From: Sarah Fawdry [REDACTED]
Sent: 02 March 2023 15:55
To: Jessica Riches; David Easton
Cc: Chris Brake; Katie Martin; Martin Kempshall; Thomas Richards; Silvie Steiningerova
Subject: Bilsham Road, Yapton - Y/70/22/DOC and Y/34/22/DOC
Attachments: 2023 02 08 Y 70 22 DOC Drainage Response.pdf; D1956-13-200B Proposed Levels Layout.pdf; D1956-13-201B Proposed Levels Layout.pdf; D1956-13-202B Proposed Levels Layout.pdf; D1956-13-300B Proposed Permeable Paving Formation Levels.pdf; D1956-13-301B Proposed Permeable Paving Formation Levels.pdf; D1956-13-302B Proposed Permeable Paving Formation Levels.pdf

Having recently picked up comments on your online portal regarding Y/70/22/DOC (dated 8 February 2023; attached for ease), please find our responses to the outstanding queries as follows. For ease and completeness, I have followed on from the previous queries with our responses, our latest response is detailed in green.

Drawing Status	FOR APPROVAL		
Client	THAKEHAM		
Project	BILSHAM ROAD YAPTON		
Drawing Title	S104-CONSTRUCTION DETAILS SHEET 1 OF 2		
Scale	NTS	Date	FEB 22
Drawn By		Checked By	
Drawing No.	D1956-15-100		
Rev.	-

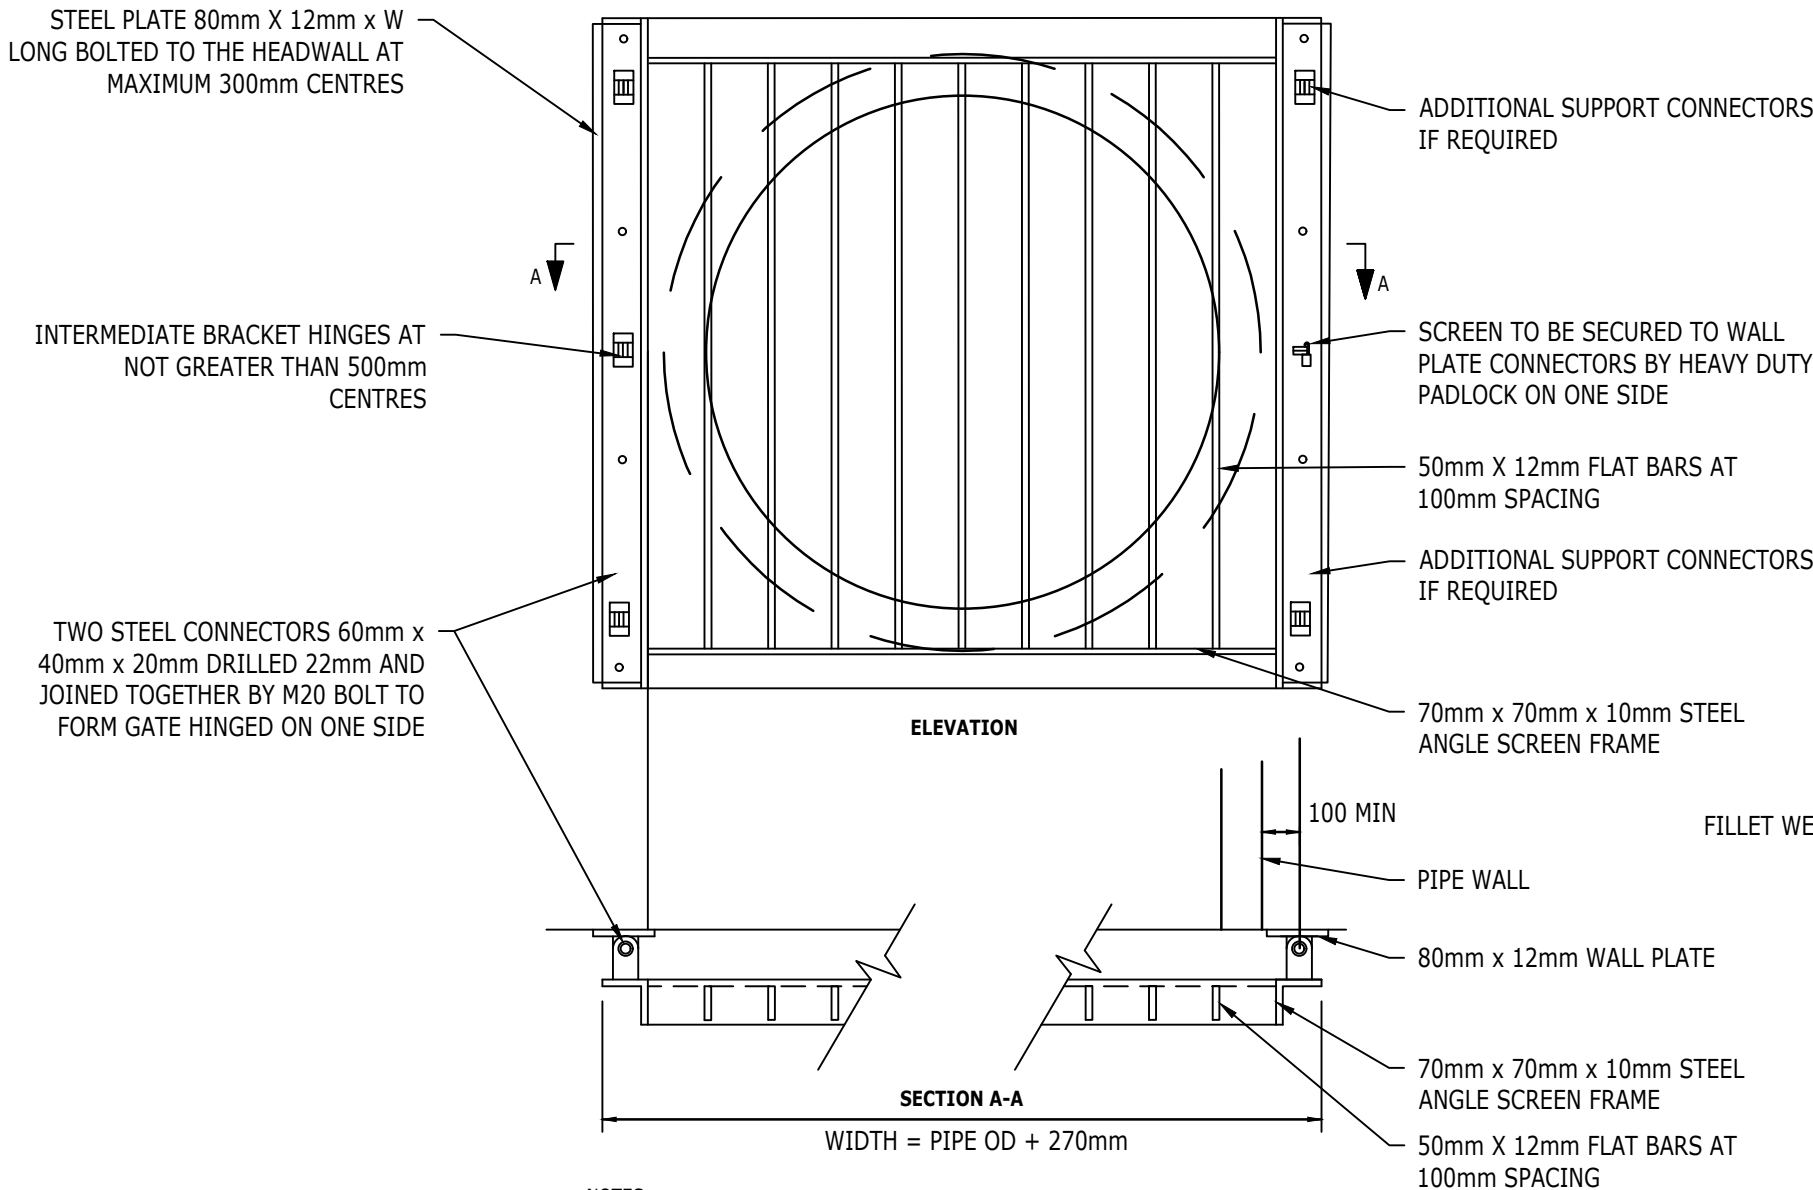
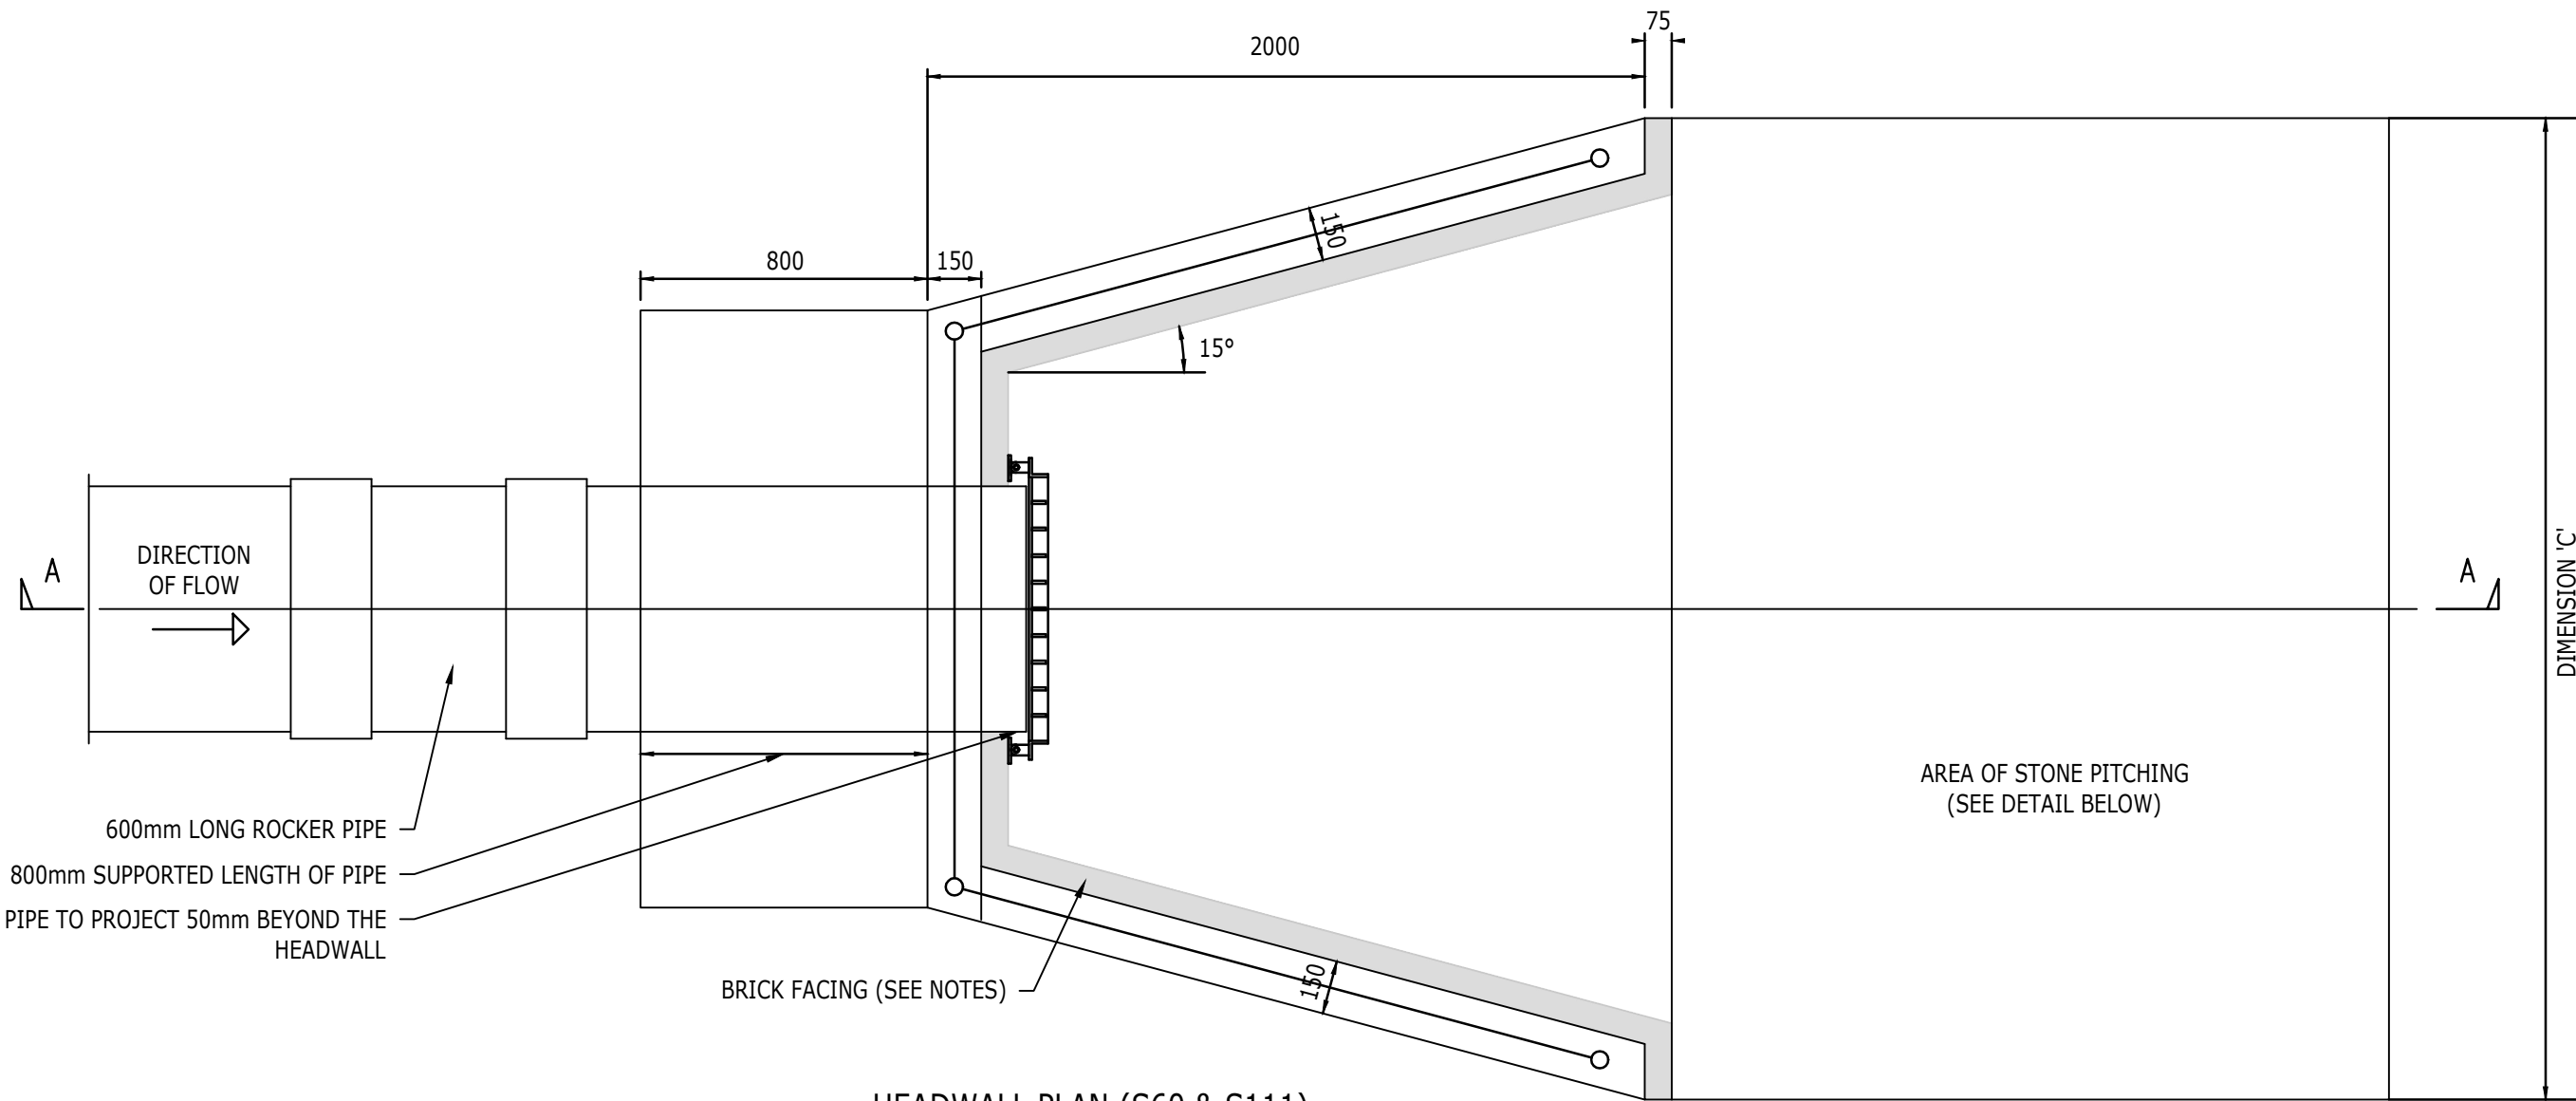
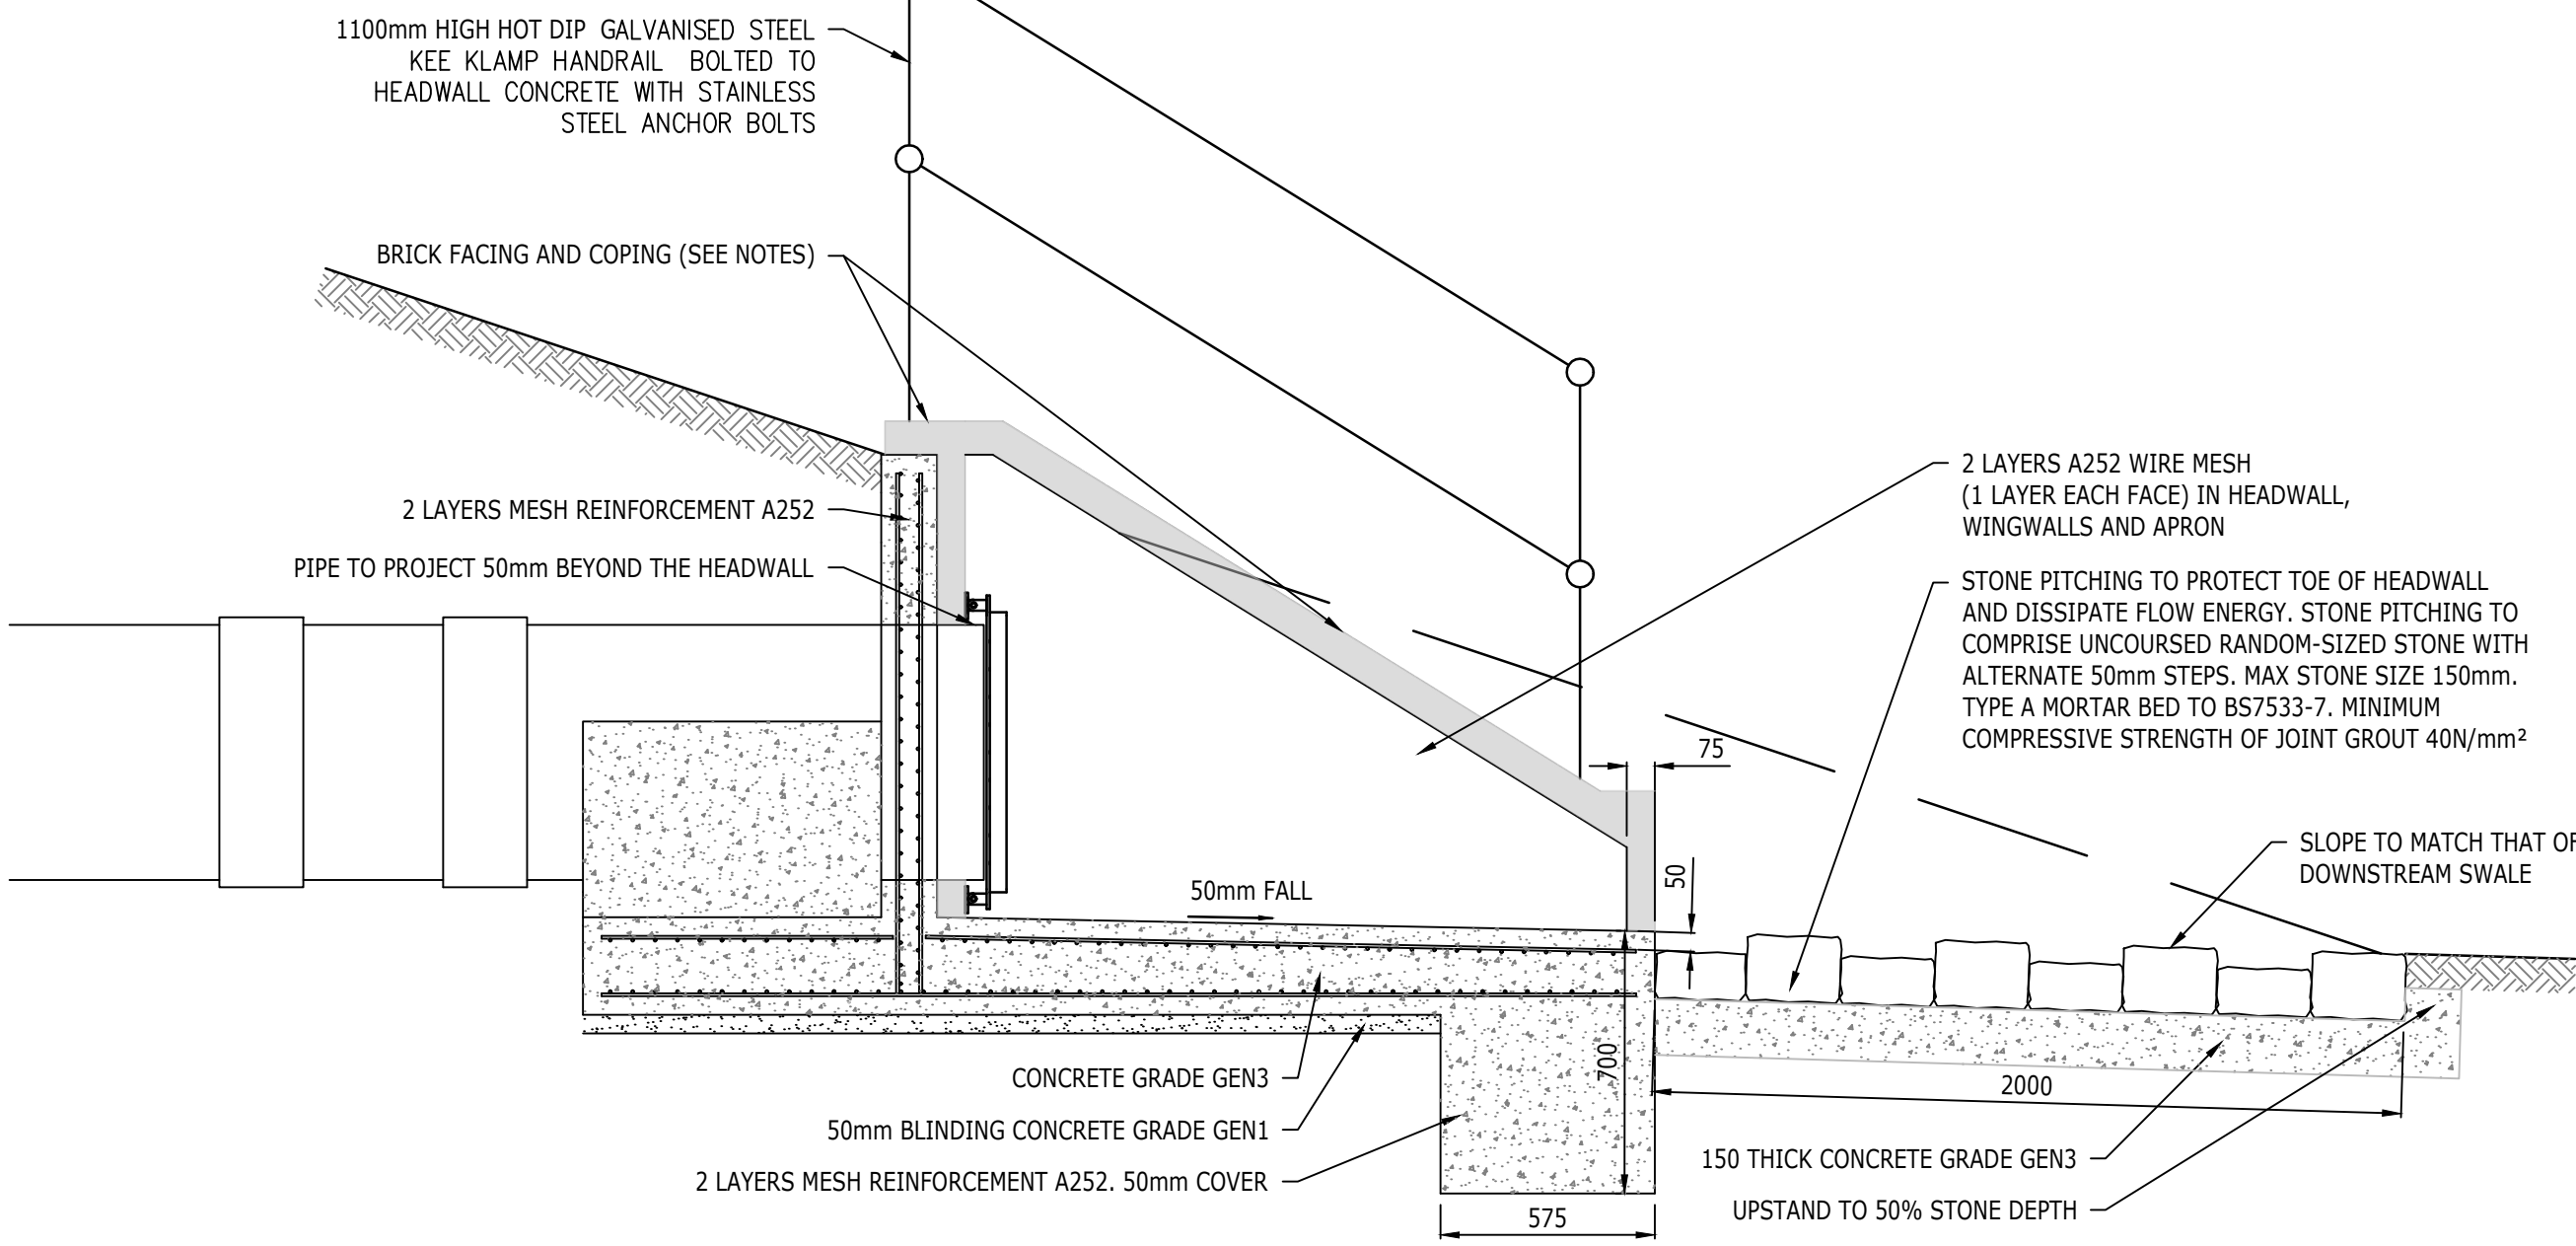
11. Please provide cranked grilles at a 45 degree angle. - Cranked grilles required on heads – S104 Construction details sheet 1 of 2 D1956-15-100 needs to be updated to suit ADC requirement. Pipe beddings details on this drawing are illegible in parts. Information needs to be clearly presented. We note that applicant's response that this is not "DSG compliant" however the drawings refer to Sewers for Adoption 7th Edition. As such the applicant needs to be clear which edition of Sewer for Adoption the adoptable drainage is being designed to. In addition they should confirm who the adopting authority will be as well as confirmation from the adopting authority on whether they will or will not accept cranked grilles. 08/02/2023- Whilst it is noted that the Technical Approval certificate has been provided for information, this doesn't clarify whether the adopting authority has considered a request to use cranked grilles. This needs to be confirmed by the adopting authority otherwise cranked grilles should be used TH: There is no provision in DCG for the use of cranked grilles, only grilles installed flat against the headwall. In addition, we consider that cranked grilles create a health and safety issue as they could encourage people to climb up on them up to a perch from which people could fall.
